[REP1-055] 7.9.1 Outline Construction Traffic Management Plan (Clean) (Rev 2)

Having reviewed the above document and associated changes I would like to raise a couple of points/questions, especially around the Barred Routes.

Figure 4.1: Barred Route Plan

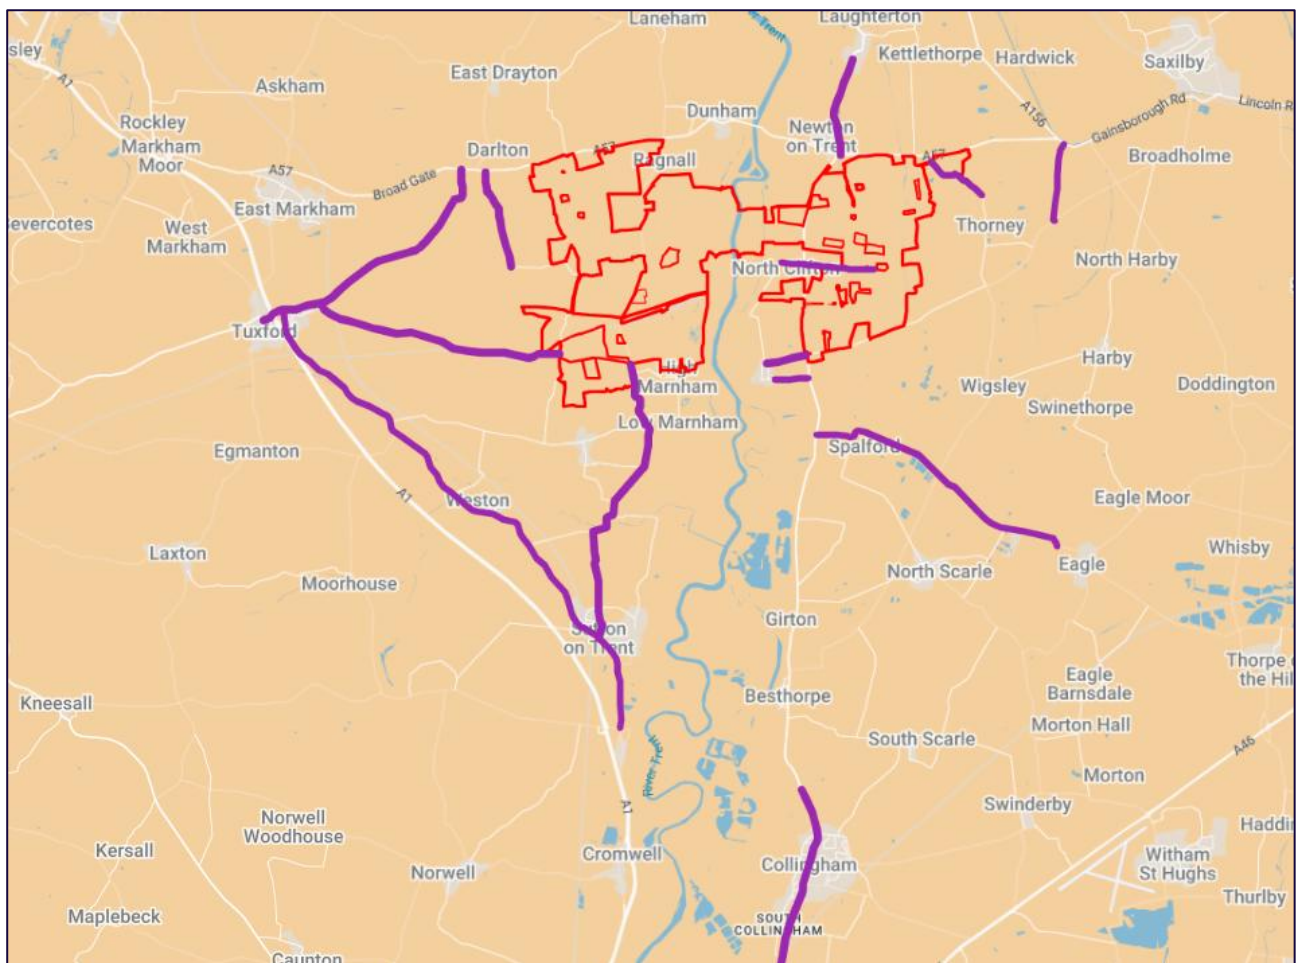
Paragraph 4.2.9 (page 14) refers to the proposed barred routes being provided in Figure 2. However, no such Figure exists within the document. Instead, the relevant plan appears as Figure 4.1. This inconsistency makes cross-referencing difficult and should be corrected to avoid confusion.

The accompanying barred routes plan (Figure 4.1) is very small and difficult to interpret. From what can be discerned, Mill Lane, South Clifton (to the west of the A1133) is shown. However, there is no clear marking of Mill Lane to the east of the A1133, despite its inclusion in the text

From Figure 4.1, I hopefully understand correctly Moor Lane, North Clifton is on the barred route list, but cannot see Mill Lane (East), leading to Cottage Lane, is marked. These roads are in poor condition, regularly requiring repair by Nottinghamshire Highways, and have very limited passing opportunities, even for two cars. They have no suitable passing places for HGVs. The junctions of both Moor Lane and Mill Lane (East

On that basis, I would expect Mill Lane and Moor Lane, North Clifton (east of the A1133) to be explicitly included within the barred routes.

The size and legibility of Figure 4.1 (erroneously referred to as Figure 2) is inadequate for residents to properly understand the barred routes. A larger, clearer plan—showing village names and road labels—should be provided so that affected communities can verify the Applicant's commitments.
